Reference No: 2021/62/92581/E

Site Address: 65, Fountain Drive, Roberttown, Liversedge, WF15 7PY

Description: Erection of first floor extension to rear, demolition of existing garage and erection of new garage

OFFICER REPORT

Client Mr & Mrs Suckling	
Job 65 Fountain Drive Roberttown	
Title Proposed garage elevations & plan	
Drawn By RK	Date dec 2020
Eng. Check	Scale 1:50
Tech. Check	
Drawing No. 2020 / 270 / 09	Rev. A

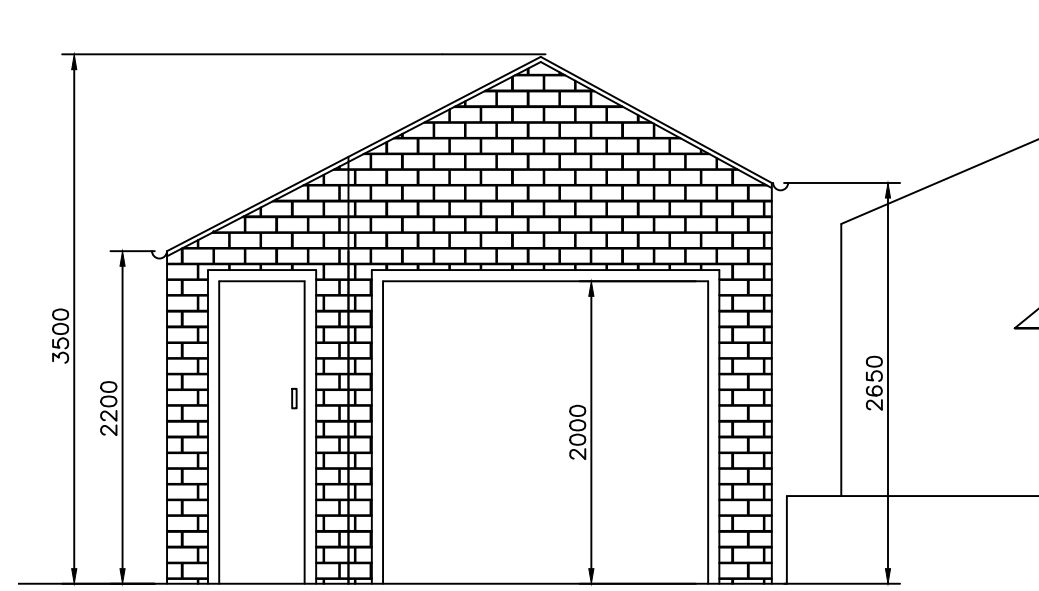
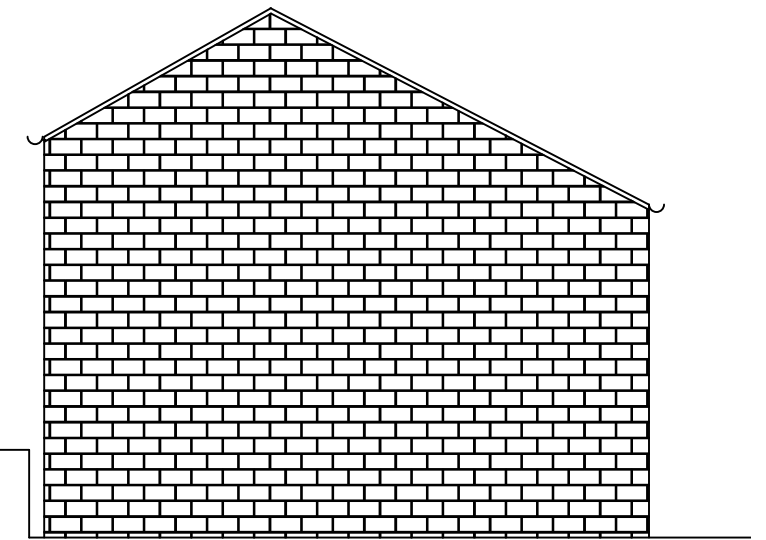
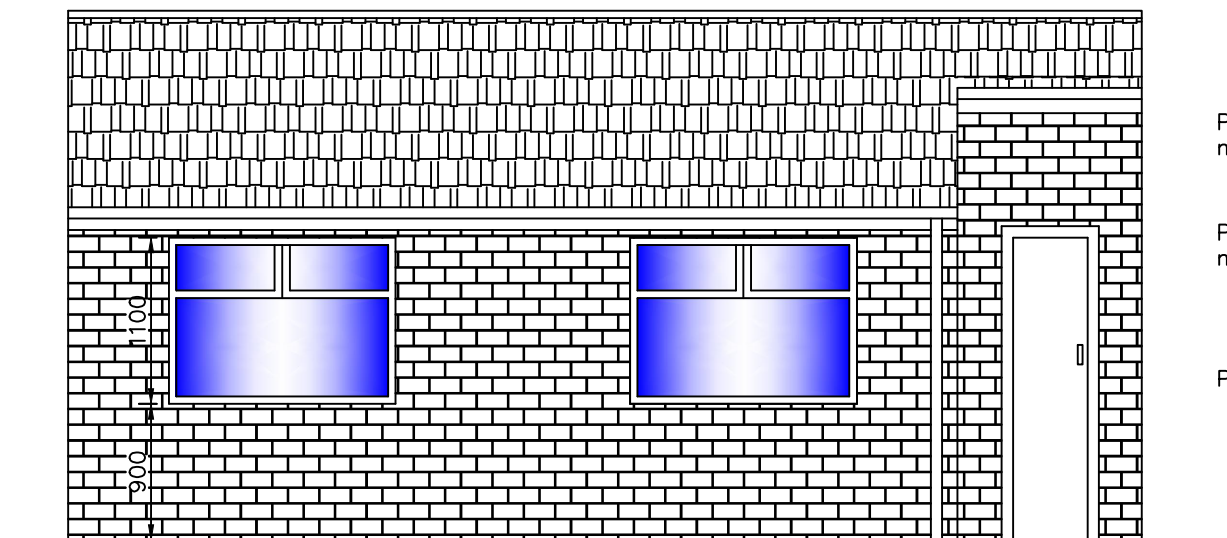
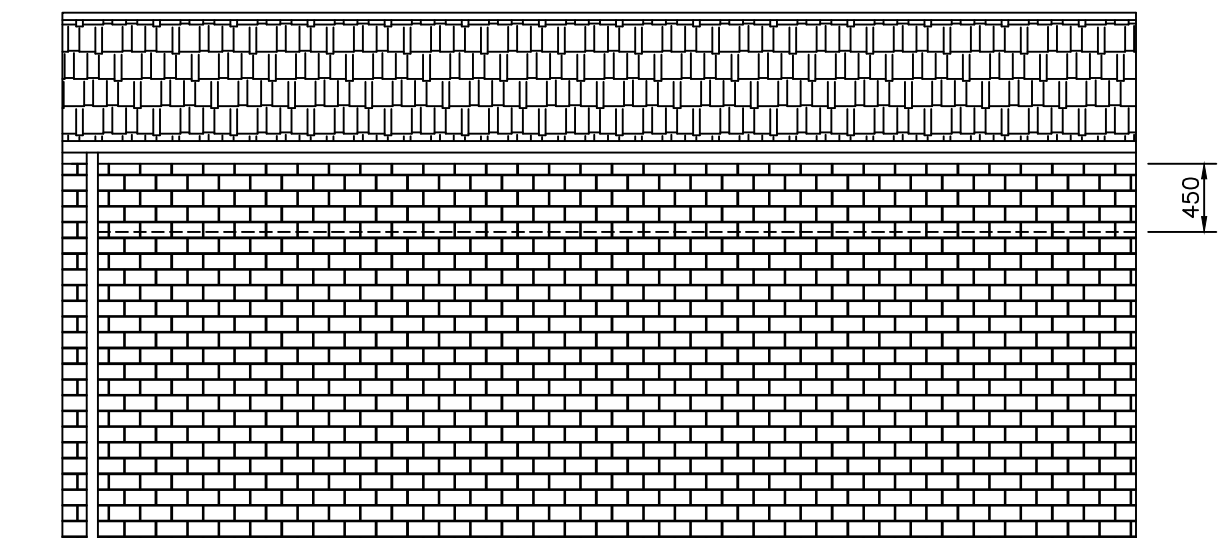
The garage would have a width of 4m, a depth of 6m, an eaves height of 2.2m and an overall height of 3.5m. The roof would have an asymmetrical roof form as approved. However, the eaves height along the shared boundary would be increased from the approved 2.2m to 2.65m.

The garage has already been approved in this location, along the shared boundary with the adjacent dwelling, as it would replace an existing structure and there is also a garage in the grounds of this adjacent dwelling. The modest increase of the eaves proposed would not have an increased impact over and above the approved scheme. Therefore, officers are satisfied that there would be no significant impact to the amenities of the occupiers of the adjoining 63 Fountain Drive.

Following the publicity, one representation was received, which did not object to the works proposed. However, it expressed concerns that the garage would extend onto common land. *This is not a material planning consideration. However, the plans indicate the garage would be wholly on the applicant site.*
